Ref: 20050/CastelmerNMA/0124

Re: Castelmer Fruit Farm, Ashcombe Lane, Kingston - Application for Non-Material Amendment to Planning Permission Ref: SDNP/22/05983/FUL

20050 – P114D (Floor Plans and Elevations Plot 10)

CLIENT:	Greenplan Designer Homes	PROJECT:	Castelmer Fruit Farm, Kingston
SCALE:	1:100 (A1 ORIGINAL)	DRAWING:	Proposed Floor Plans and Elevations Plot 10
DRAWN:	RPO	20050	P114
DATE:	14.10.22		D

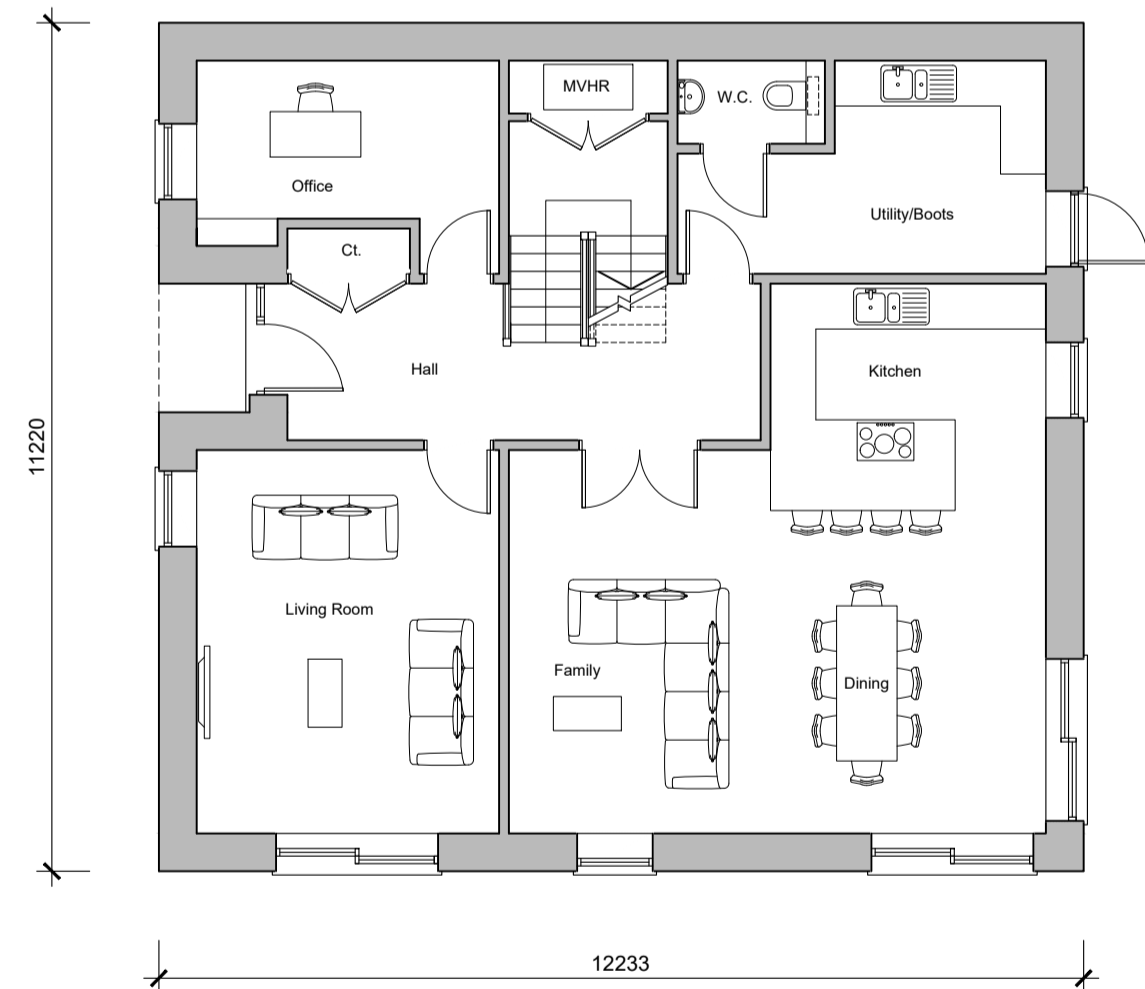
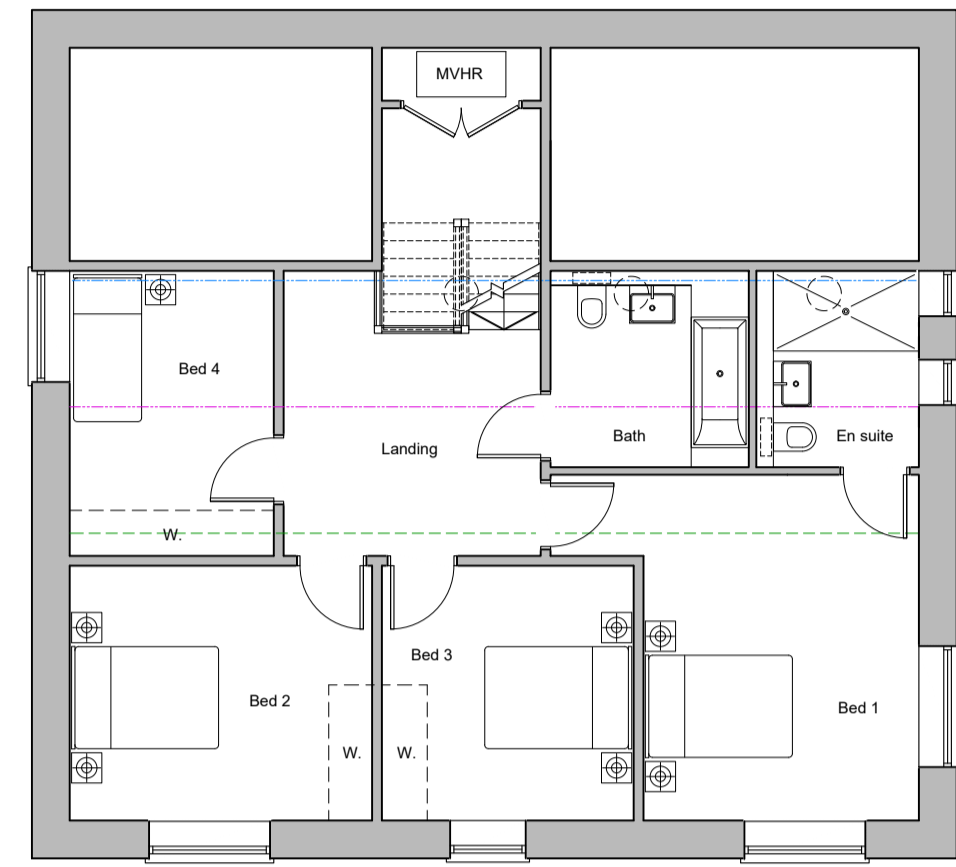
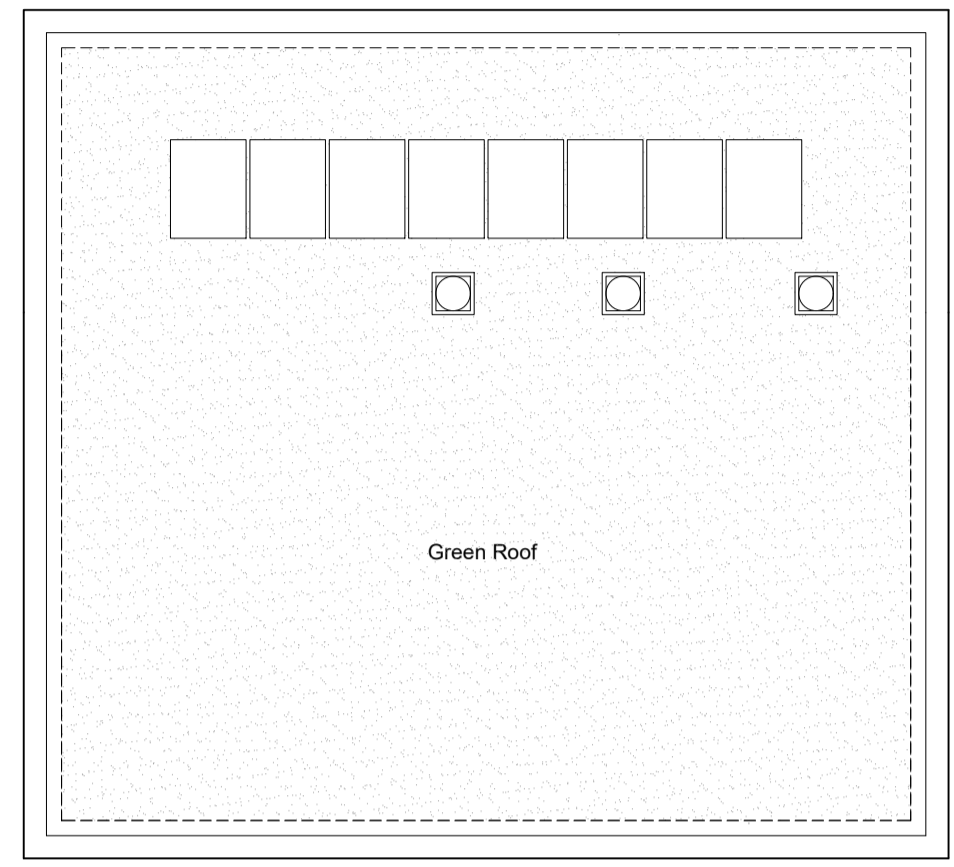
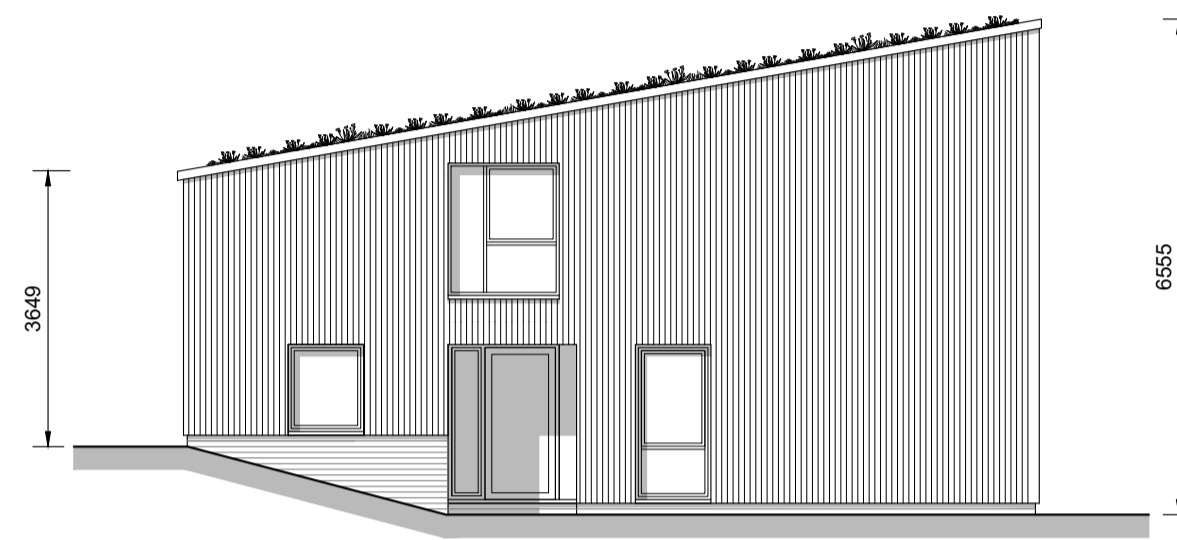
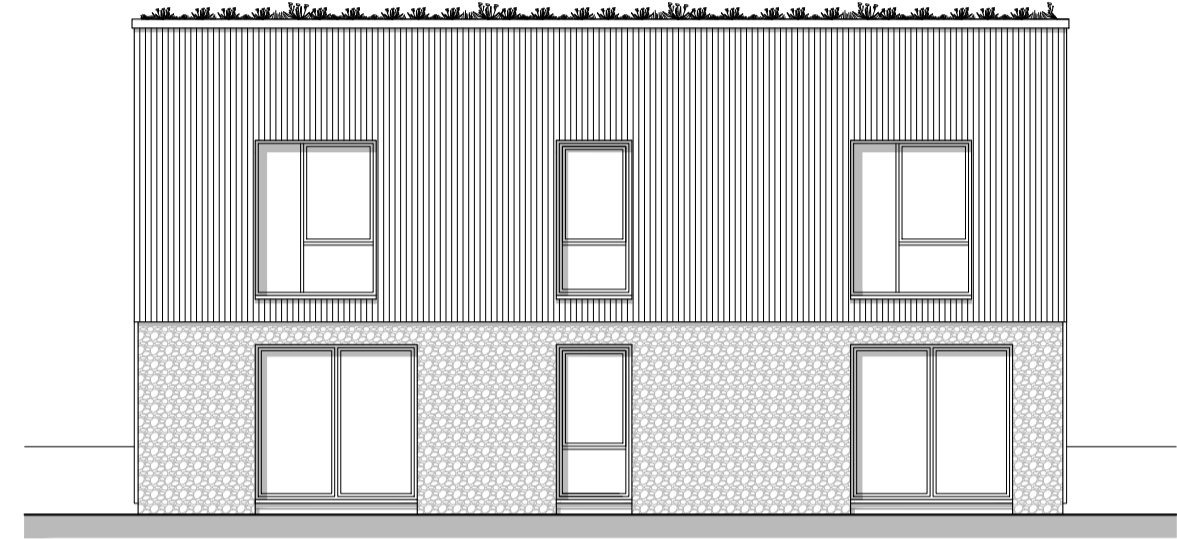
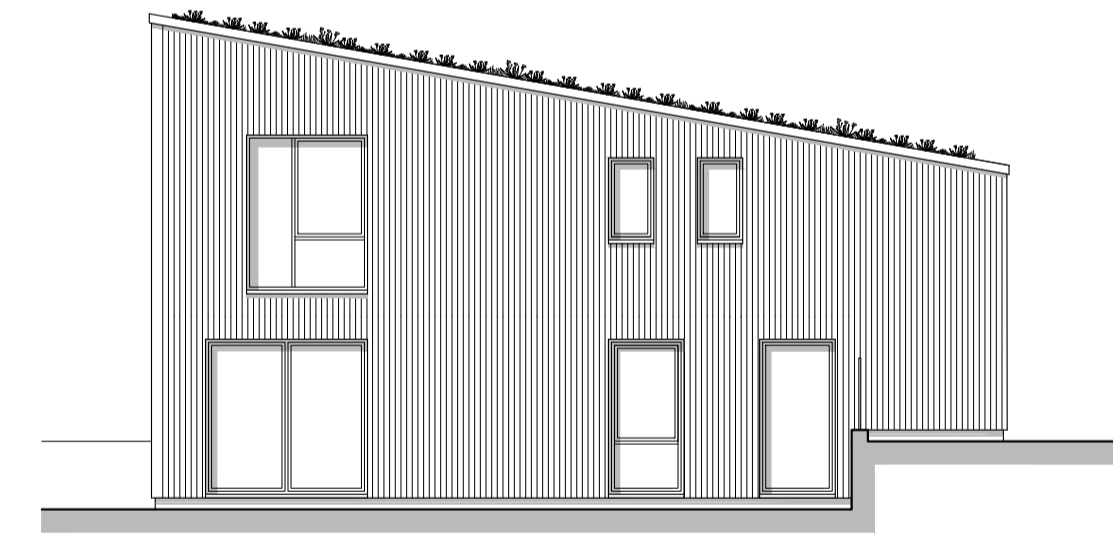
Plot 10 has been designated a Passive House design under the extant approval. In developing the design for Passive House standards, there are several minor changes that are required, notably:

- The location of the central MVHR unit against an outside wall and central to the floor plans to serve all rooms.
- The collation of all non-habitable wet rooms (kitchen, utility, bathrooms) to the colder, north facing side of the building. These rooms have also now been stacked to minimise drainage runs.
- A slight reduction in glazed area overall, to reduce heat gain in the summer months.
